KEY ISSUES SUBMISSION	
PROPERTY:	Lot 200 DP 1192140 17 Croobyar Road Milton
FILE REFERENCE:	Council Reference: 3A21/1000 Department Reference: SSD8845345
PROPOSED DEVELOPMENT: (SUMMARY)	Budawang School for Specific Purposes
PROPONENT:	NSW Department of Education

Additional Referral Responses

Shoalhaven Water

PLAN SHOWING SPOT HEIGHTS, CONTOURS, BUILDINGS, ROOF HEIGHTS, ADJOINING BUILDINGS, TREES AND UNDERGROUND SERVICES OVER LOT 200 D.P.1192140 CROOBYAR RD MILTON.

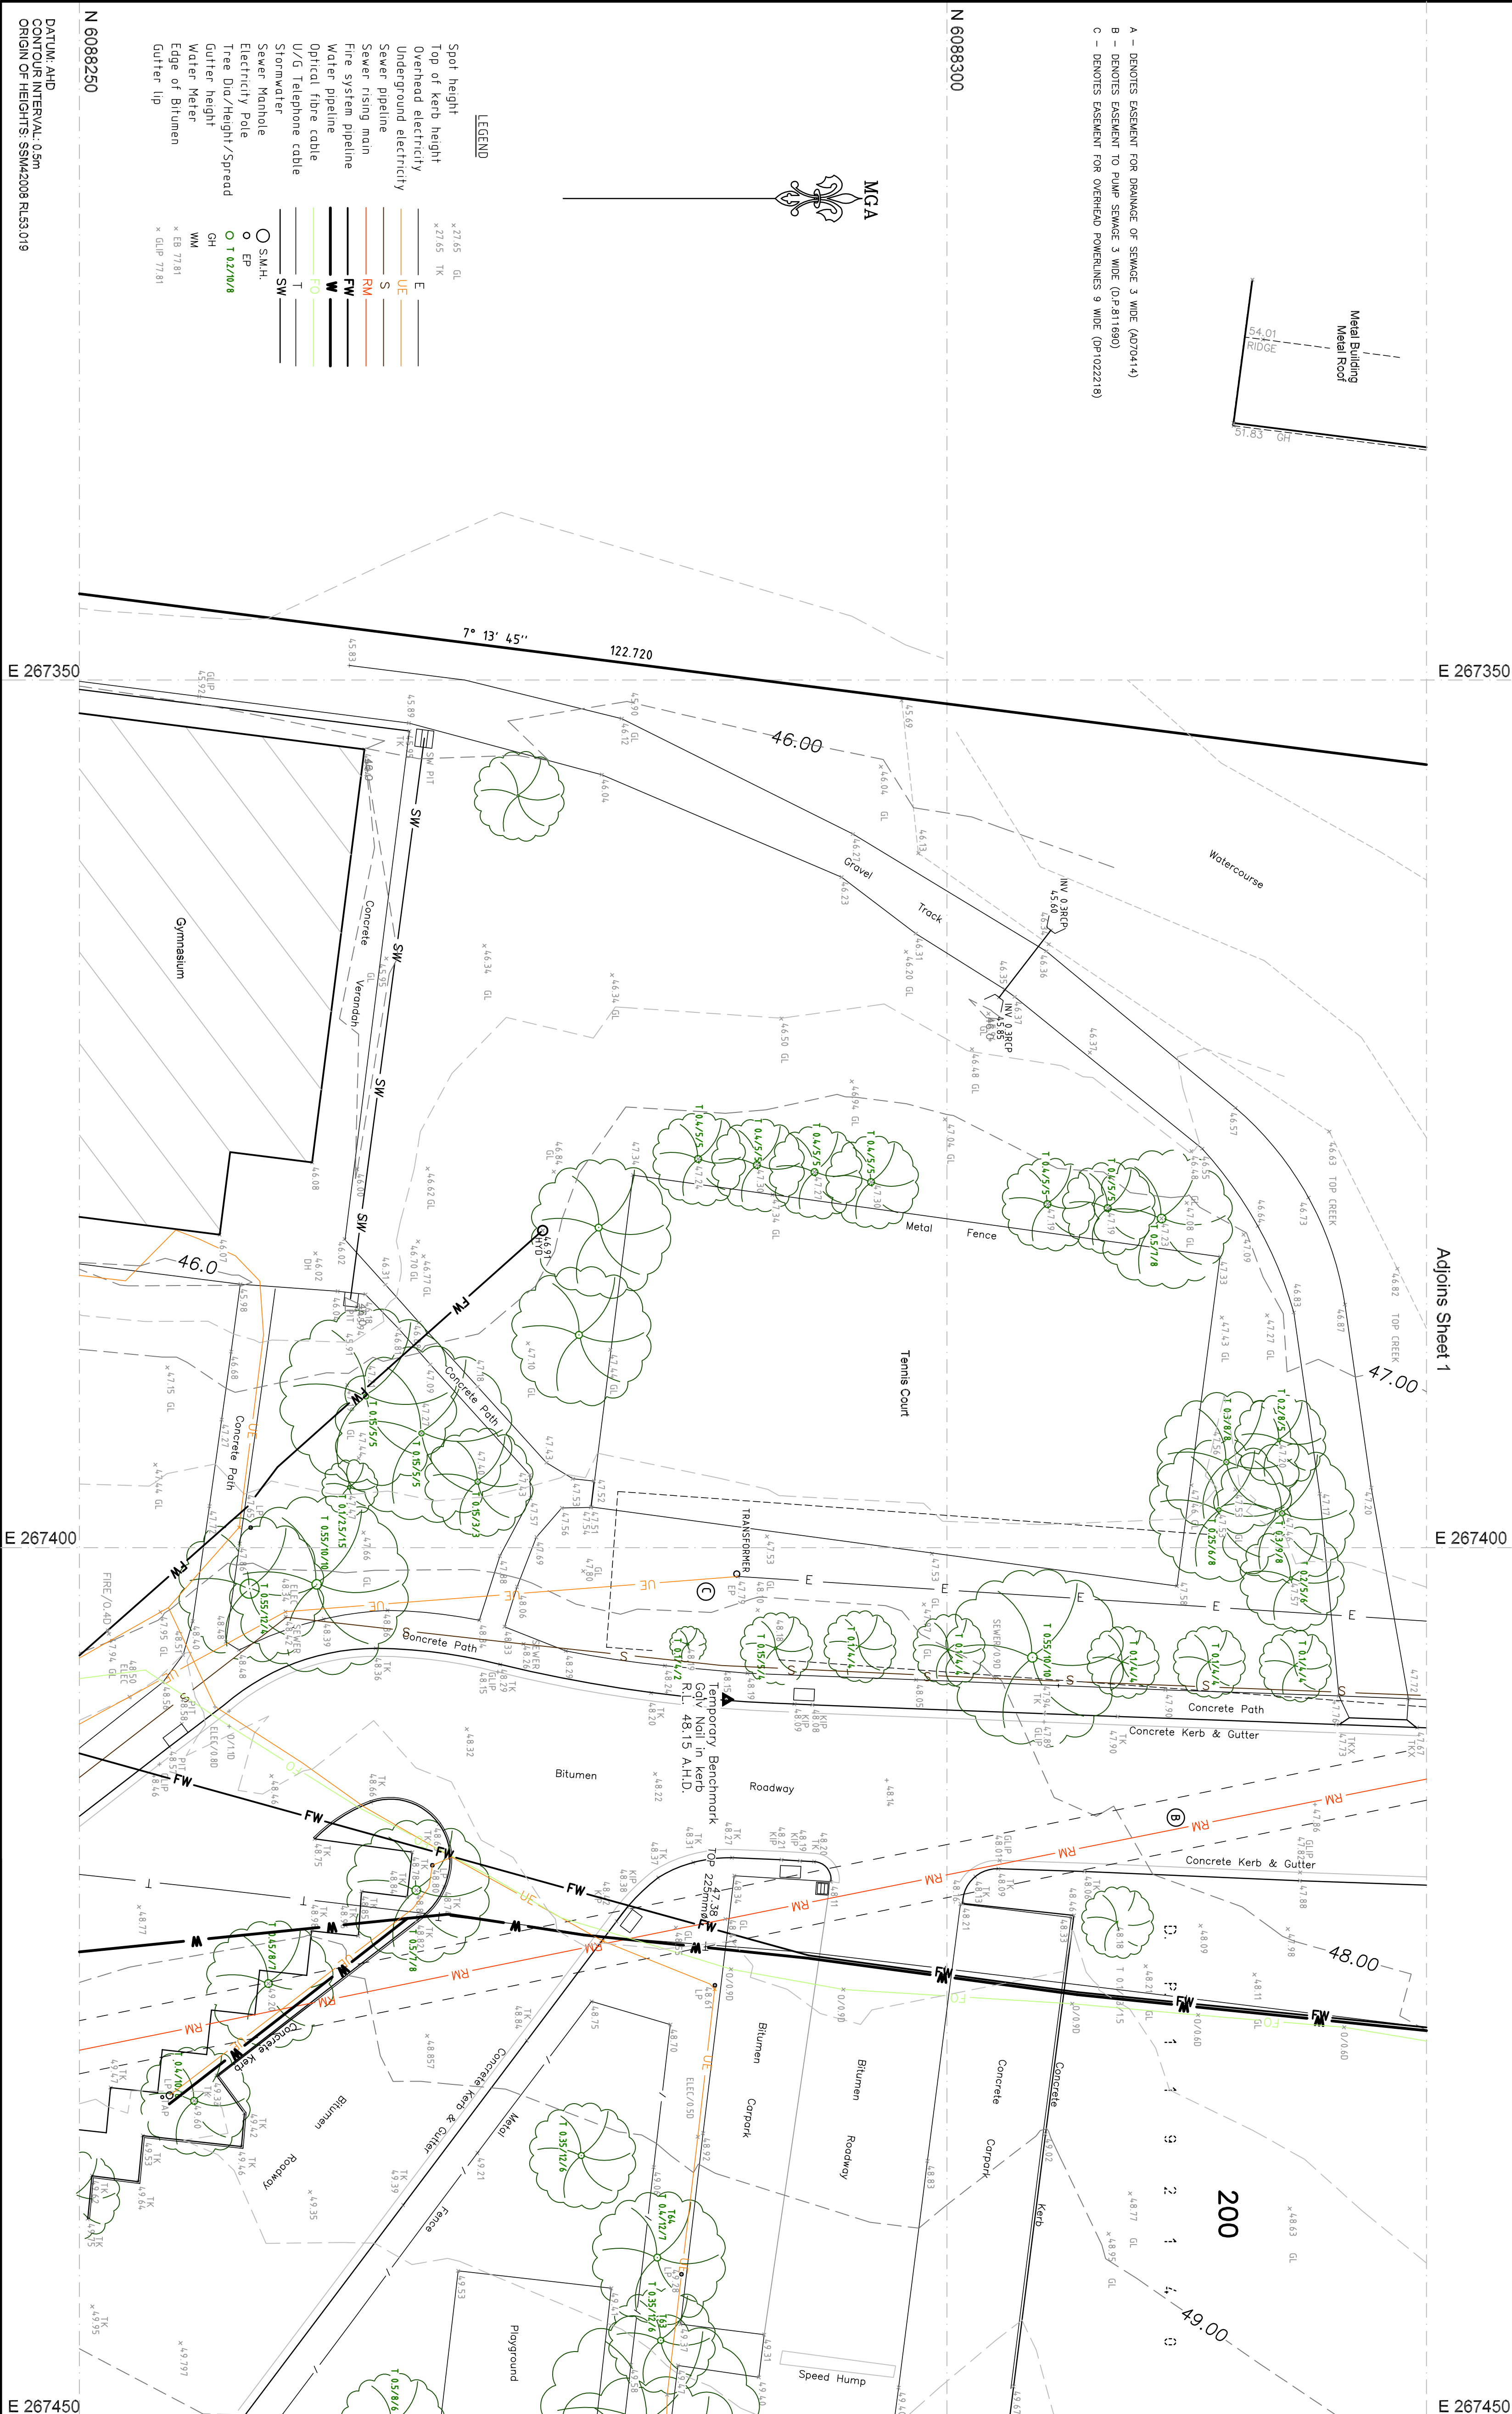
Council has a critical sewerage asset that traverses through the site. The asset is a DN225 AC/C Sewer Rising (Pressure) Main. This sewer rising main (SRM-M3) transfers the bulk of the sewage from Milton township to the next sewage pumping station.

The exact position of the sewer rising main (SRM) needs to be identified on a survey plan (including depths) and transferred to the architectural and engineering plans. It is appropriate that a long section for this SRM be prepared showing all structures within the zone of influence and what action is proposed for protection.

Council's Building Over Sewer policy POL16/81 clearly outlines that structures are not permitted to be constructed over sewer rising mains that are greater than DN150 in size (Section 3.1.1 *Restrictions*). The policy also states under Section 3.5.3 *Foundation Requirements* that screw piles are NOT to be closer than 2.0m to a sewerage pipe.

- 750mm cover shall be provided over the DN225 AC/C SRM where located within trafficable areas, and
- 600mm cover shall be provided over the DN225 AC/C SRM where located within non-trafficable areas.

4 BLOCK D HYDROTHERAPY CROSS SECTION 3  
1:100

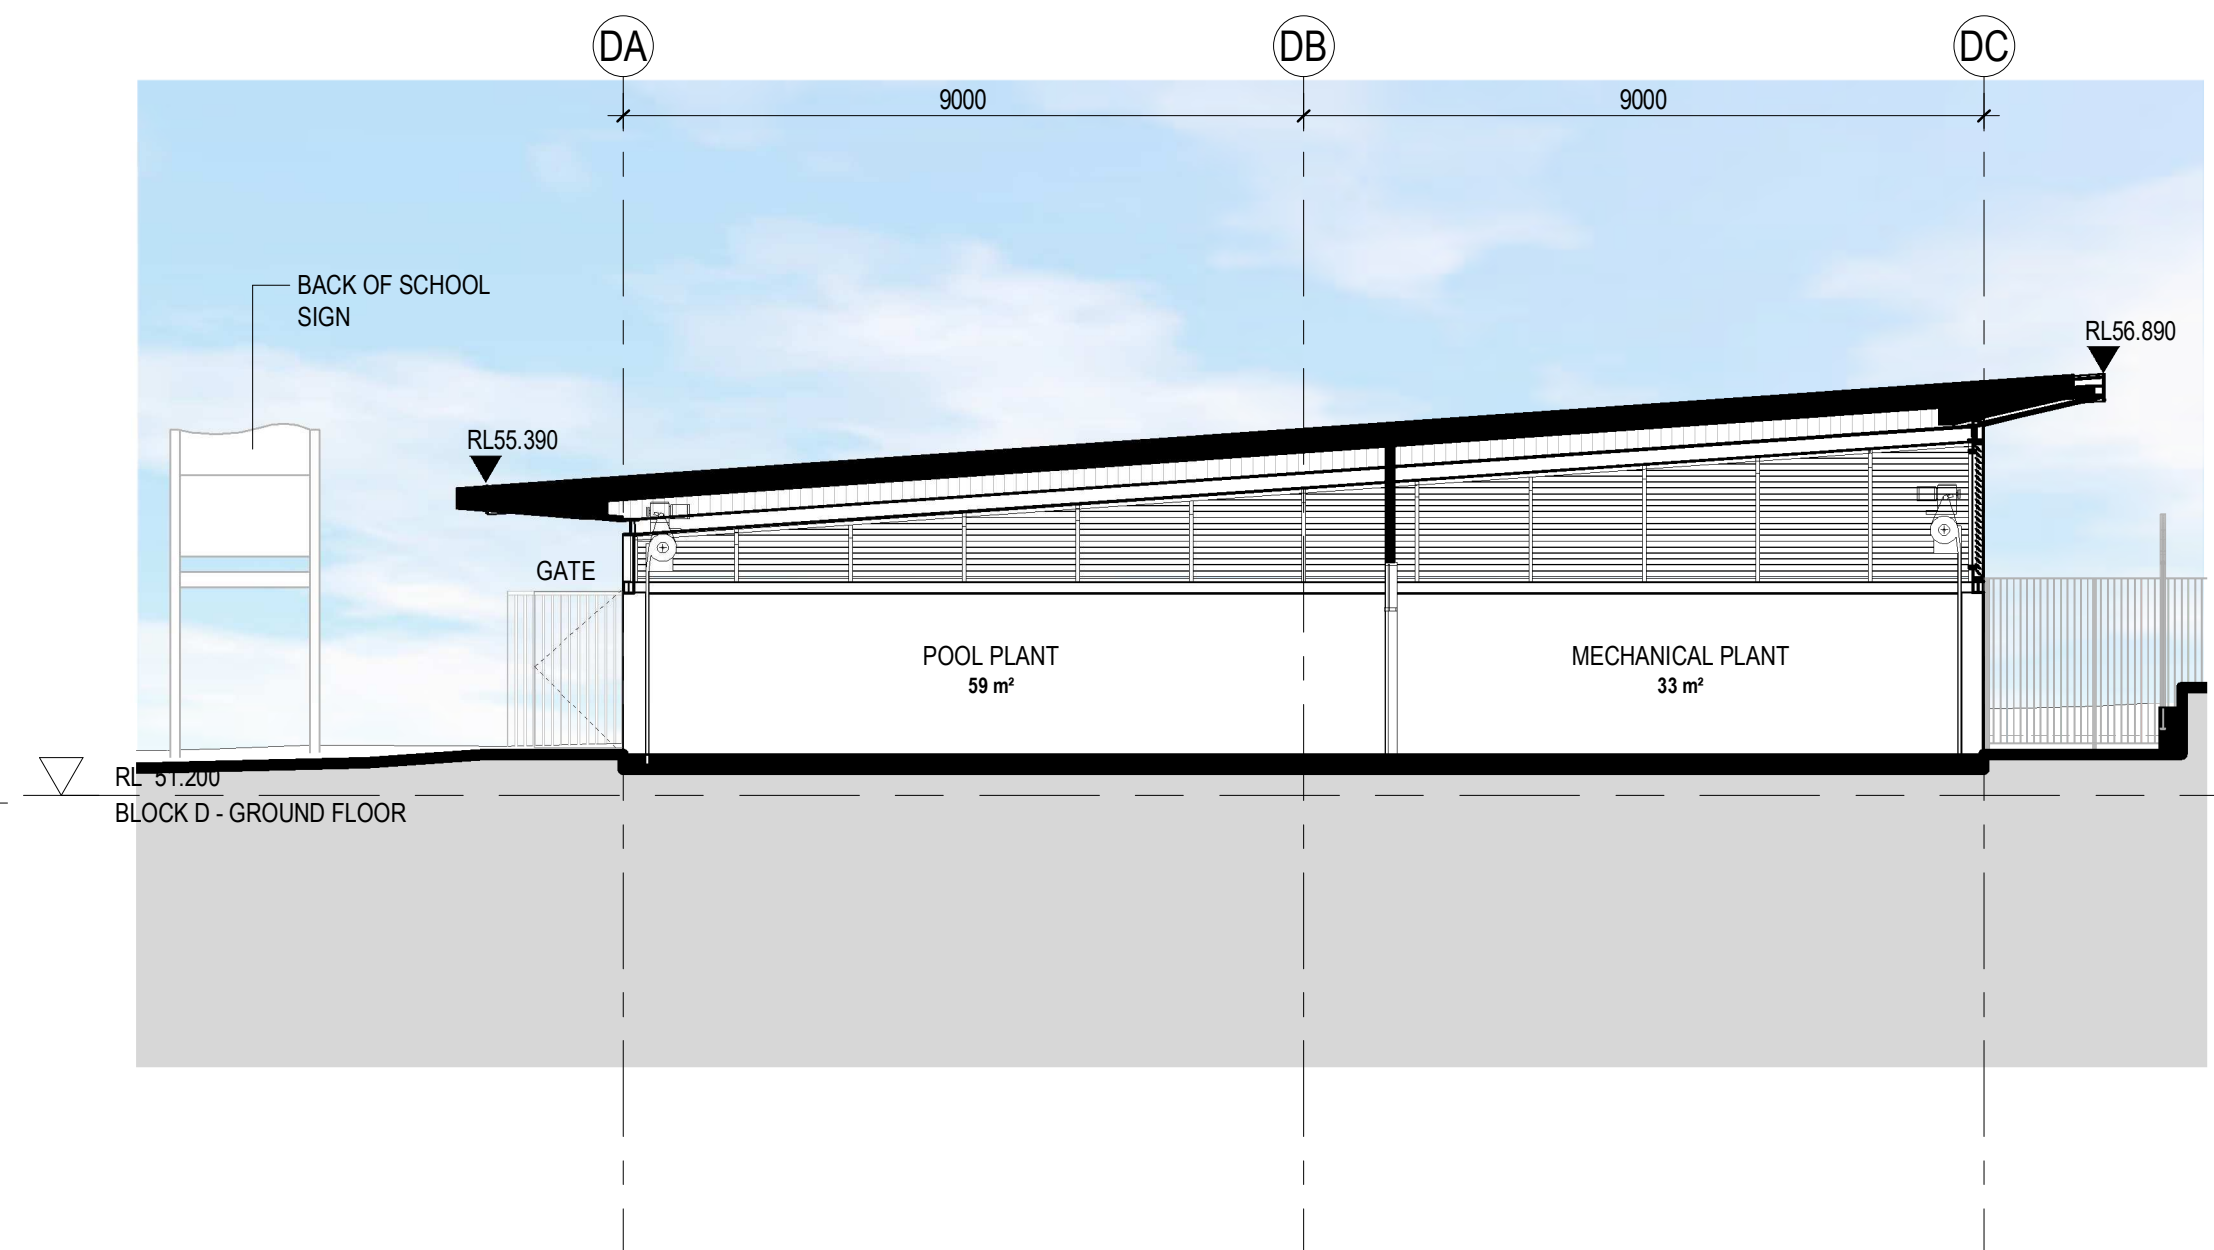
The existing sewer main M#A/2 to DE located within the front of the property within the proposed cart park (at the loading bay) next to the Hydrotherapy building (refer to Section 11/C101 on drawing No. 2091_CC_C111, rev 4 dated 27-07-21 by henry&hymas) is not shown on this cross section.

The sewer main appears to finish very close to the Hydrotherapy building. There are no dimensions to show the potential impact. Does the sewer main need to be shortened/modified?
